Narrabri Gas Project – Environmental Impact Statement Review

Thank you for your correspondence of 20 February 2017 inviting the Division of Resources & Geoscience (the Division) to comment on the Environmental Impact Statement (EIS) for the Narrabri Gas Project (the Project) submitted by Santos NSW (Eastern) Pty Ltd (Santos) on behalf of its joint venture partners.

Existing and proposed infrastructure at Bibblewindi

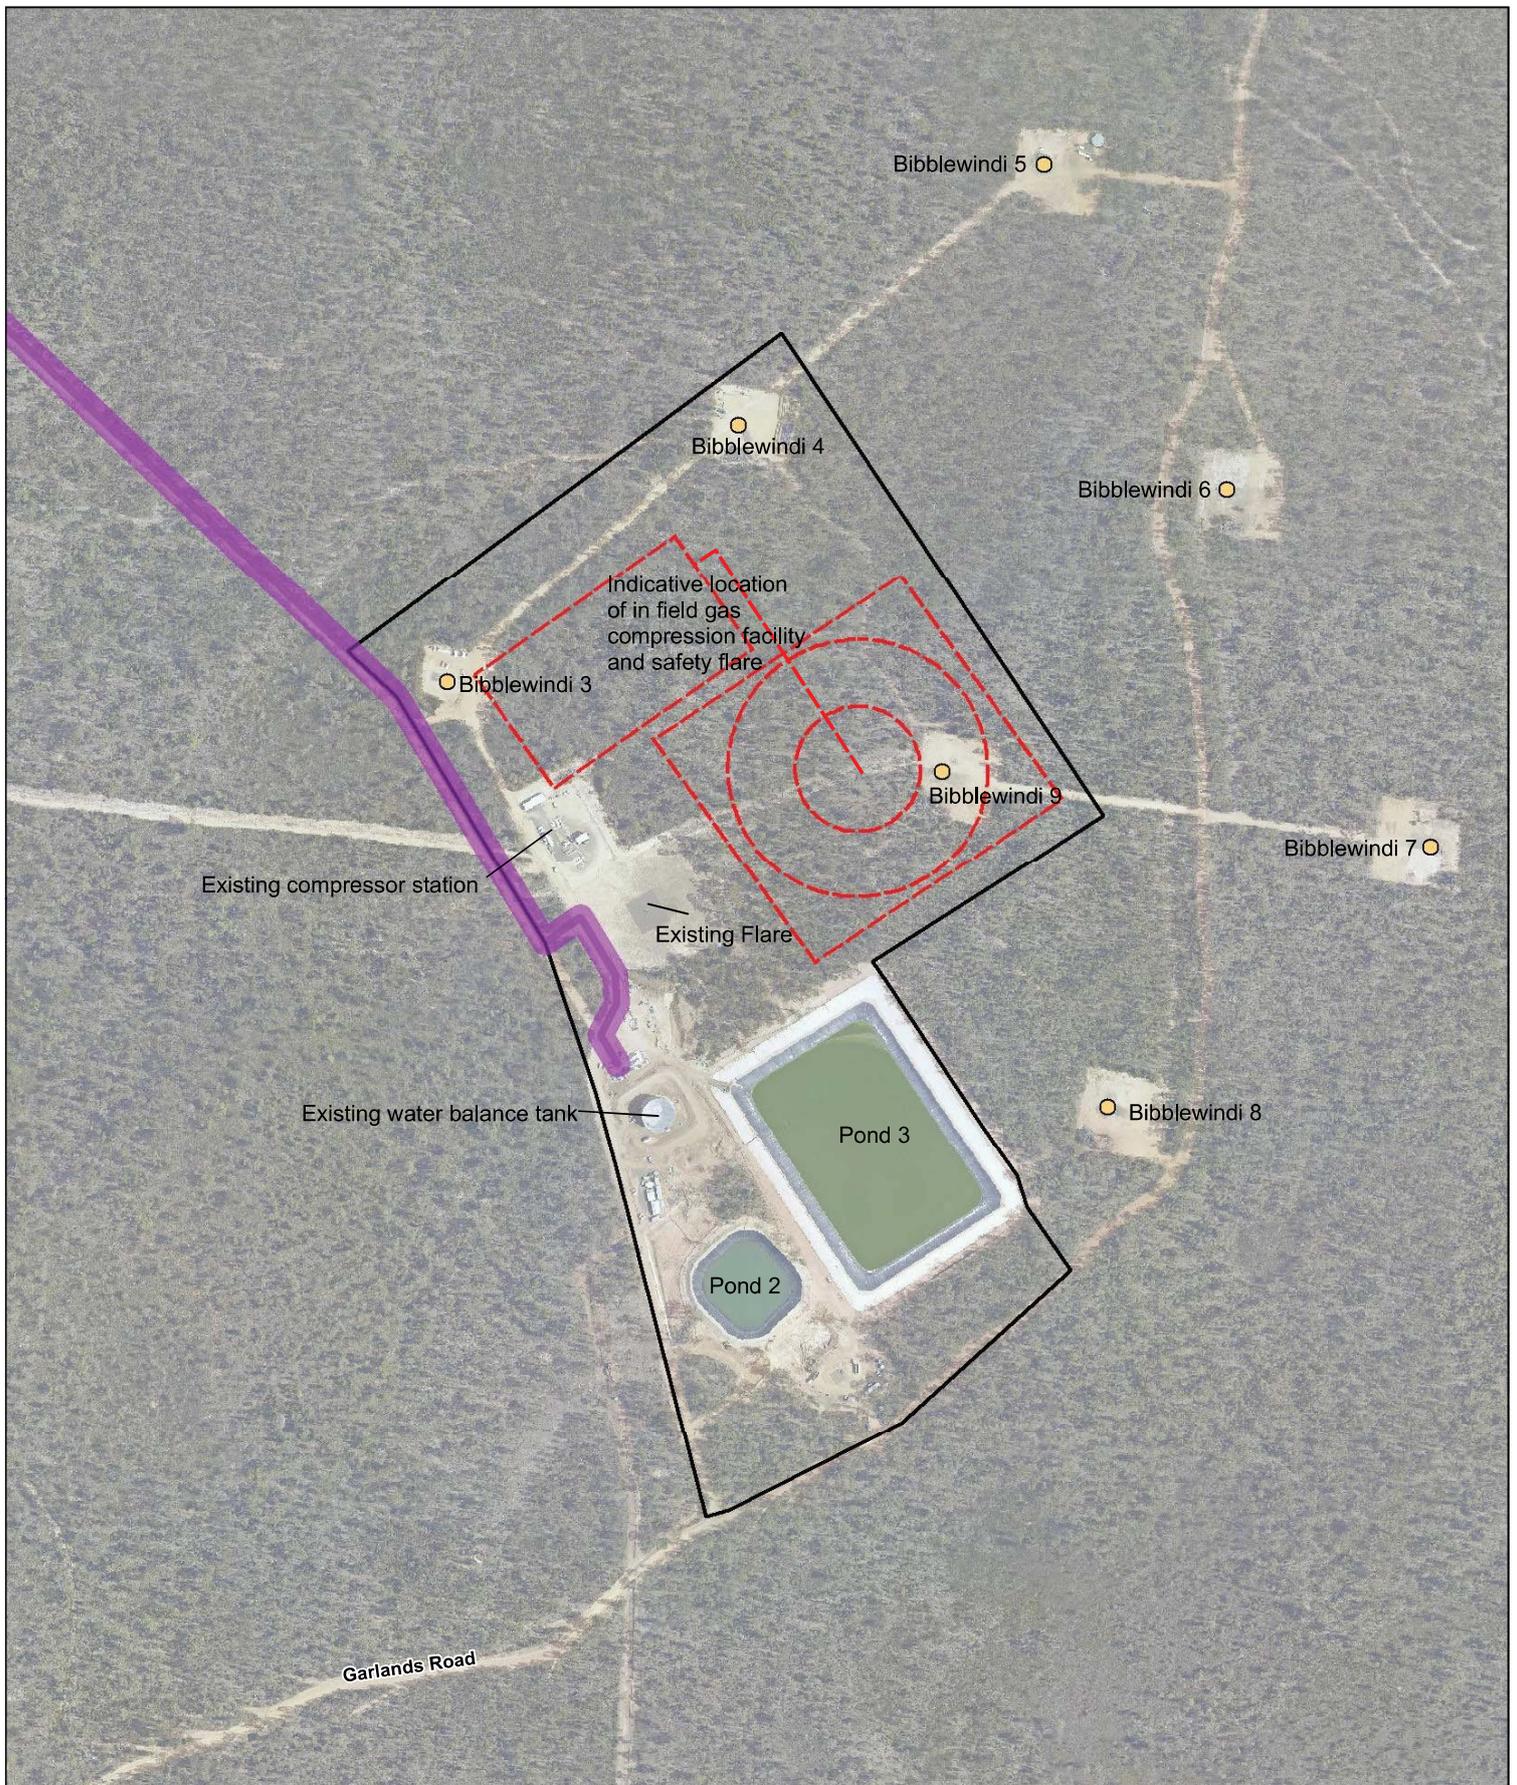
Conceptual final landuse plans are required for the Leewood and Bibblewindi infrastructure areas to clarify the final landform for the produced water storage ponds located at these sites and if any infrastructure is to be retained.
